Overlay of applicant's site layout plan and Newbridge Settlement Plan Map Ref: V2-N:11.1

SITE LAYOUT PLAN—SHEET 1 @ 1:500

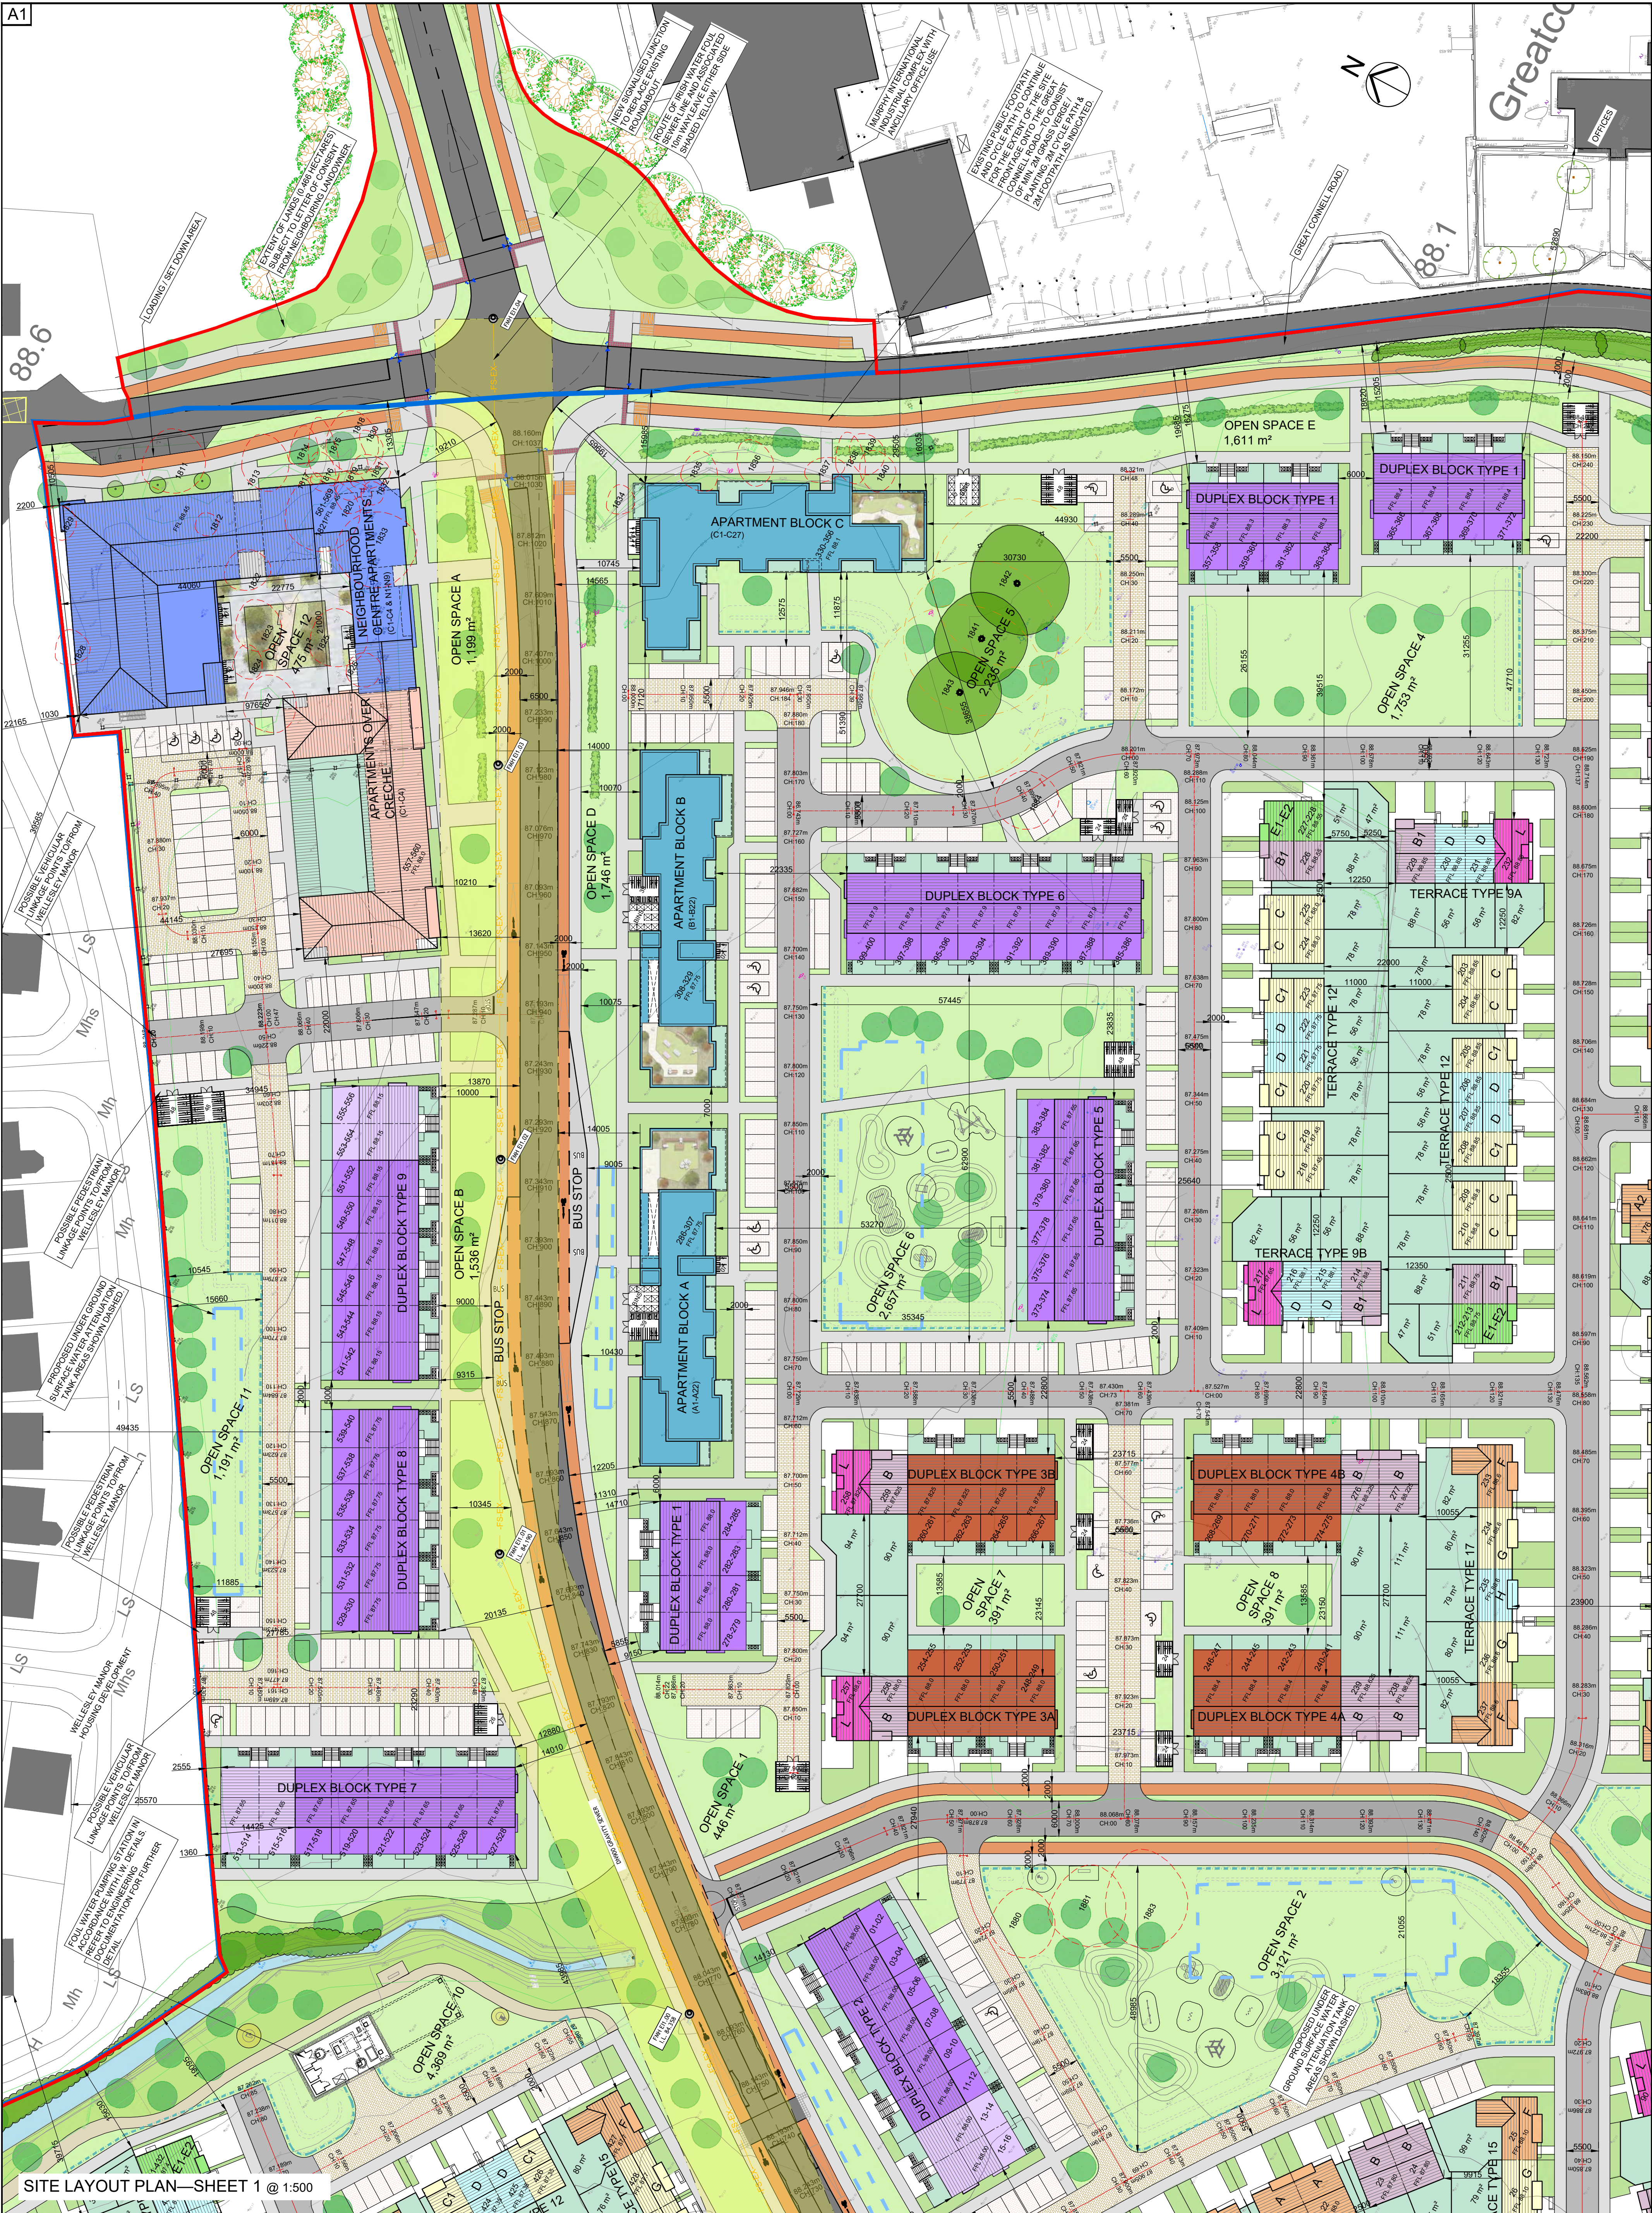
The zoned land is in accordance with the Newbridge Settlement Plan and does not have regard to Material Alteration No. 53 which seeks to replace Open Space lands with Residential zoning.

This map illustrates the original road layout and which does not align with approved permission for the Road.

The zoned land indicates the area of residential and open space zoning in accordance with Proposed Material Alteration No.53. It is clear that a significant number of houses/ parts of sites are located on lands zoned for open space use, though less than originally proposed prior to Material Alteration No. 53.
